Consultation Response from KC Highways Development Management
2019/92855 Corfe Close/Windmill Lane, Birstall, Batley, WF17 0JW
Erection of 7 dwellings
Date Responded: 18-10-2019
Responding Officer: Mark Berry
Responding Ref: 13-8NE-21

This application seeks approval to the erection of 7 two bedroomed dwellings at Corfe Close/Windmill Lane, Birstall, Batley

1 Proposed Site Layout Plan  
1 : 200

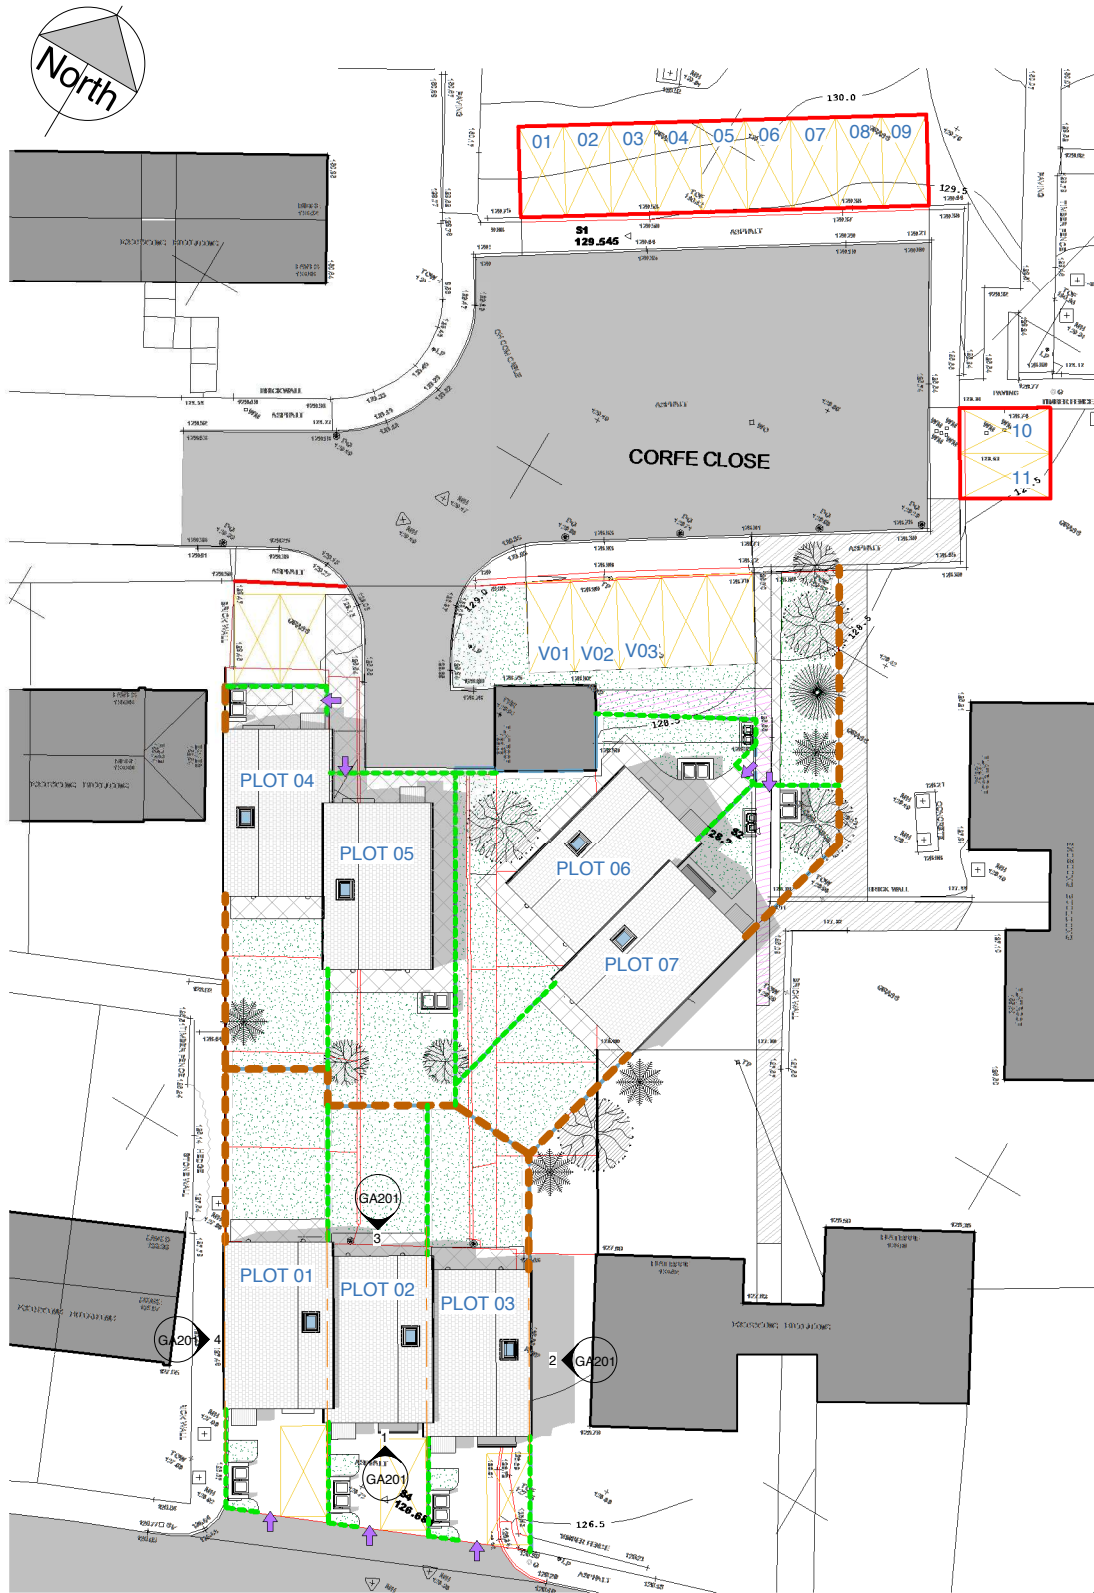
Plots 1 to 3 have one off-street parking space within a driveway to the front and a bin storage point.

There is no footway along Windmill Lane to the frontage of plots 1 to 3.

No bin collection points are shown.

Any application should include the provision of a new 2 metre wide footway to the Windmill Lane site frontage

A footway should also be provided across the existing access from Corfe Close. Access to the sub-station can be provided by a vehicular dropped crossing.

Bin collection points should be provided to allow bins from the new dwellings to be presented on collection day without obstructing the footways on Corfe Close or Windmill Lane.

DRAWING TITLE
Proposed Offset Parking Strategy

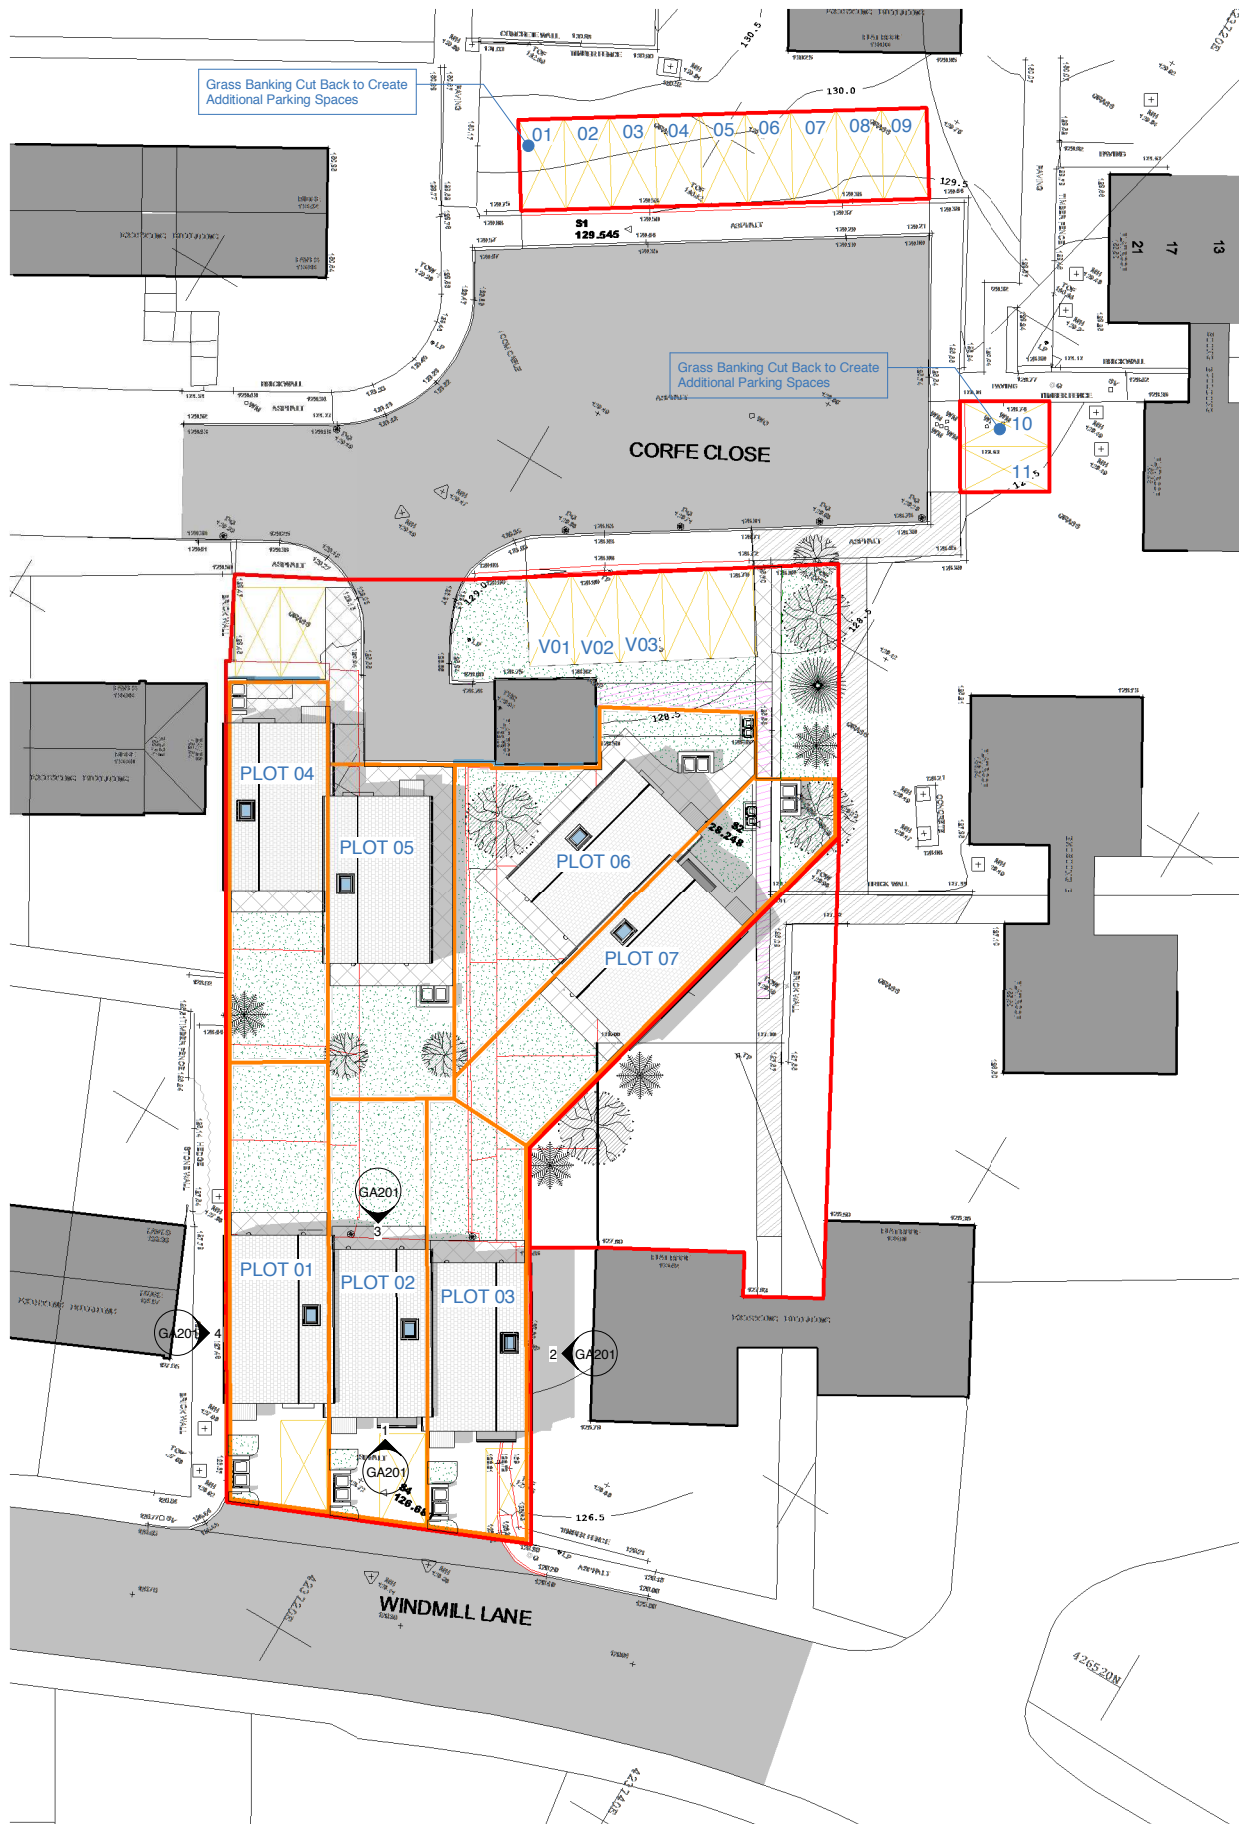
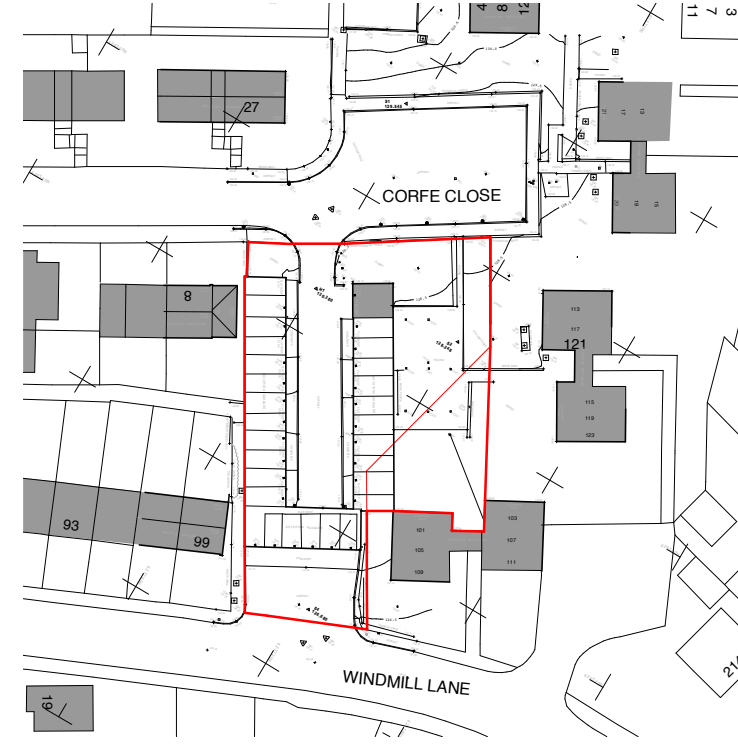
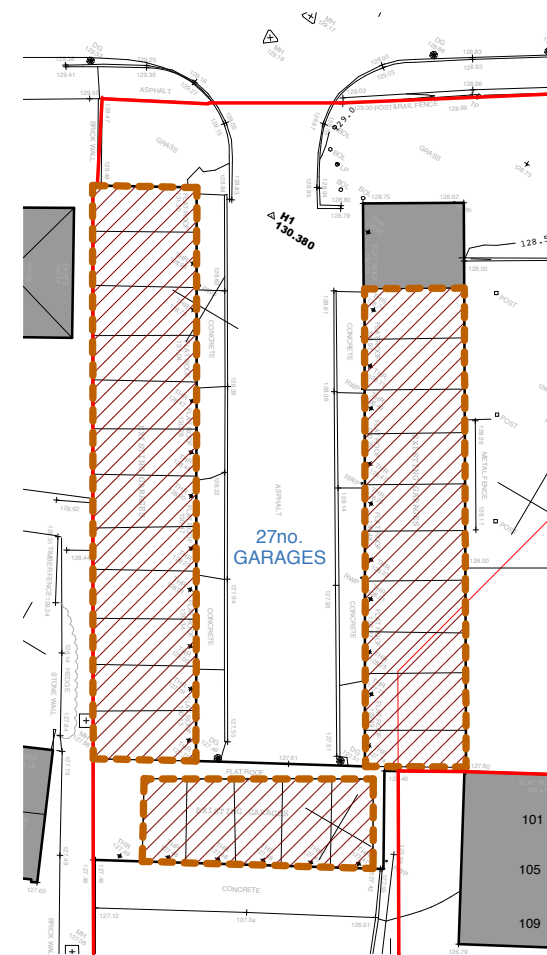
Plots 4 to 7 have parking along the Corfe close frontage. 7 spaces are proposed including 3 visitor parking spaces.

11 spaces are shown to be provided within the existing grassed verges surrounding the existing parking court to Corfe Close. Given that residents already park within the parking court this additional parking can't be considered to provide new parking spaces in companion for the loss of the existing garages.

27 parking spaces are lost within the existing garages with no new spaces provided in compensation. The proposed additional parking formalises the existing parking arrangements.

This application should consider the loss of the existing garage parking spaces. Highways Development Management would not wish to support this application if it cannot be shown that this proposal will not result in the displacement of significant numbers of off-street parking onto the adopted highway.
